Proposed Dargues Gold Mine Project Modification 3

Thank you for the opportunity to respond to the Proponents Response to Submissions report for the Dargues Gold Mine proposed Modification 3 dated November 2015.

Warren Sharpe OAM
Director Infrastructure Services

PROJECT TITLE
DARGUES GOLD PROJECT –
TAILINGS STORAGE FACILITY (TSF)
STAGE 1

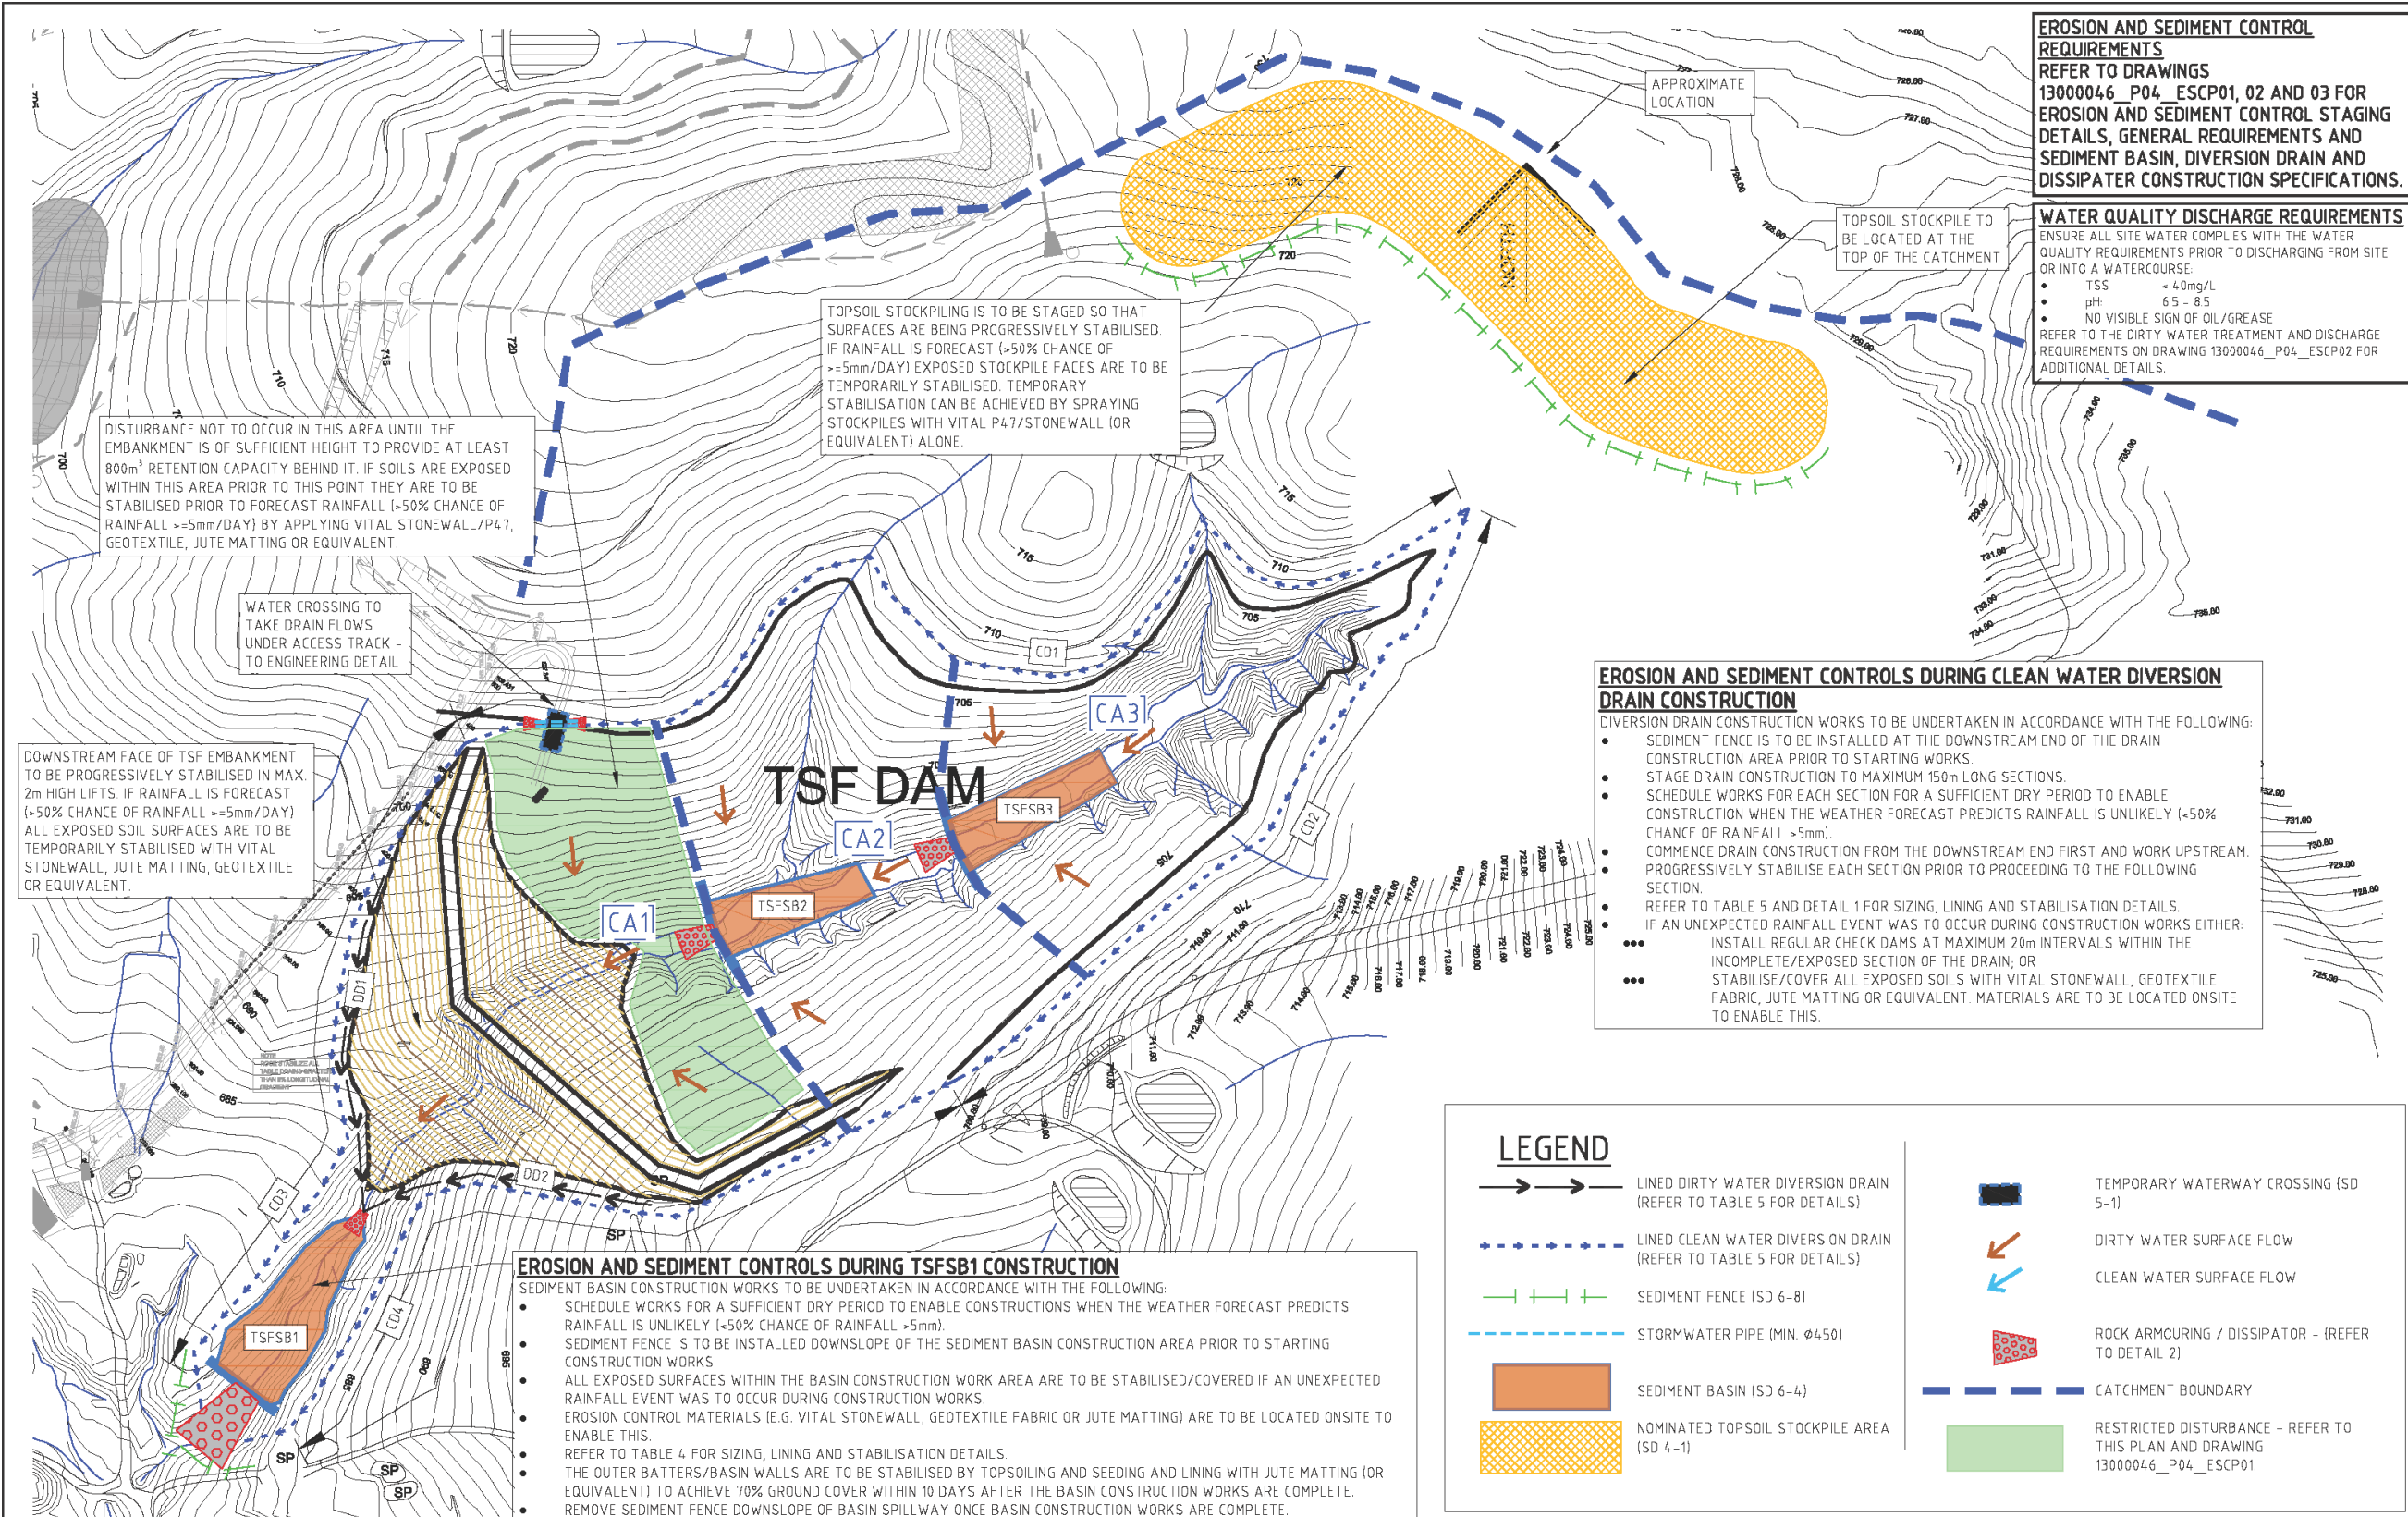
Critical review of all elements should be undertaken, including the capacity and stability of cut-off drains above the Tailings Storage Facility.

- Erosive runoff velocities due to the slope of the embankment (18°)
- Instability due to geological faults in the vicinity of the TSF
- Subsidence due to previous mining activity at the site.

Council therefore contends that the proposed Tailings Storage facility is inappropriately located.
